**Consultation Response from KC,
Highways Development Management****2023/90348 Former Hillhouse Bowling Club, King Cliff Road, Birkby, Huddersfield, HD2 2RR****Erection of community sports complex (within a Conservation Area)****Date Responded: 09/06/23****Responding Officer: CNB****Responding Ref: K5-9SW/58**

This application is for the erection of a sports complex consisting of indoor two 5 a-side football pitches and cricket net, two squash courts, gym and associated facilities including a café, reception, and admin areas and 7 car parking spaces on the site of an existing bowling green and club house.

SITE PLAN
 1 : 500

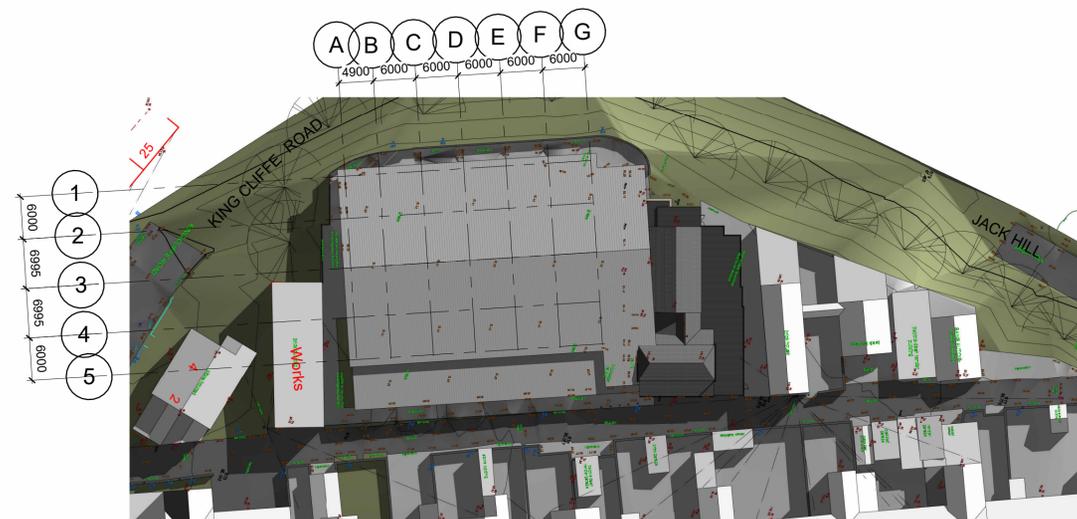
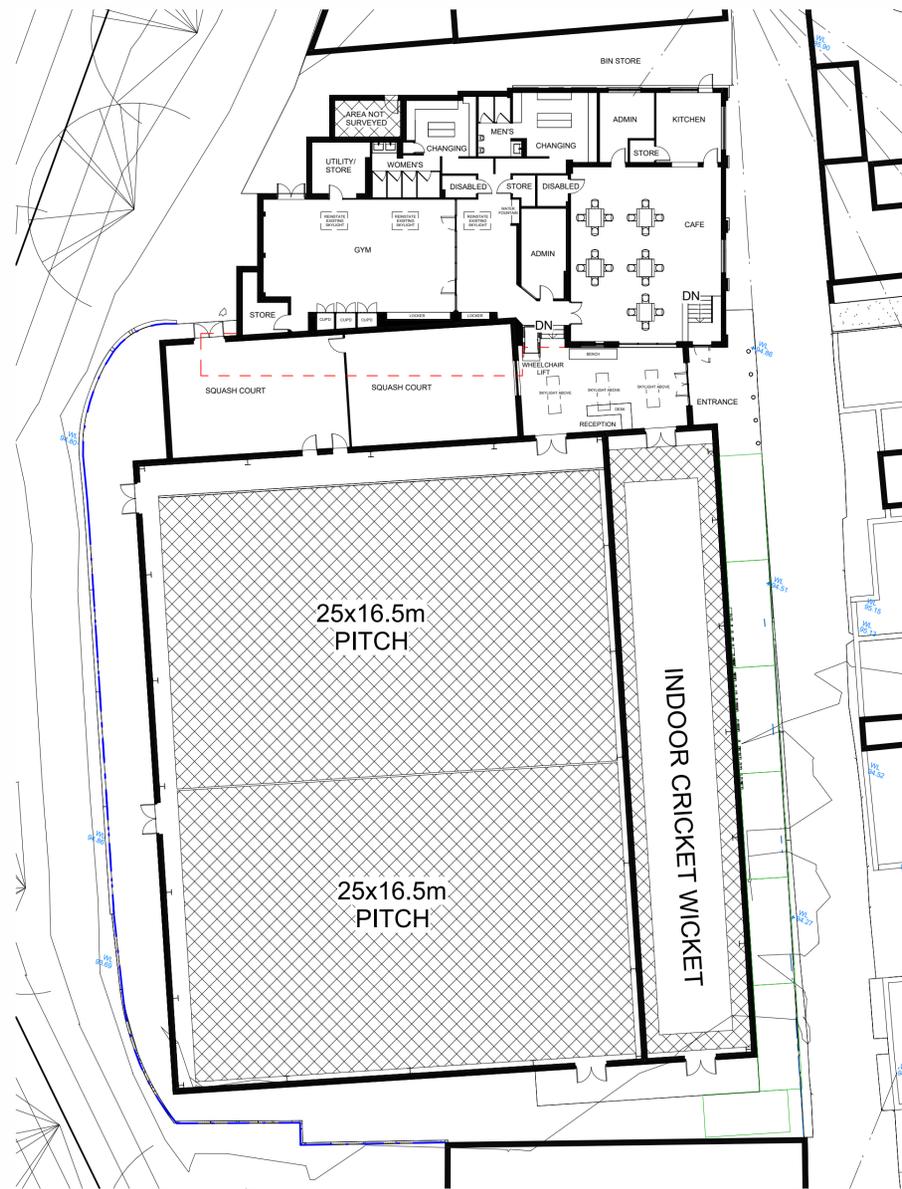
The main concern that we have is in relation to parking, especially with the limited on-street availability combined with the high existing demand. The development proposes 7 off-street parallel parking spaces located between the edge of the building and the highway. We carried out a parking accumulation analysis using TRICS data giving arrivals and departures over the full week day, and this showed that the parking demand would exceed the proposed 7 spaces for 12 hours during a normal week day (between 9am and 9pm although this would depend on site opening hours), with parking demand being as high as 19 vehicles, meaning the overspill parking of 12 vehicles would be dispersed on to the already over subscribed local highway network. This would be unacceptable to Highways and would likely cause parking and road safety concerns and unsociable parking may lead to an increase in the obstruction of accesses and dropped kerb crossings.

With this we do not feel that we can currently support the application with only 7 off-street parking spaces and so we wish to object to the application on highway safety grounds in relation to parking.
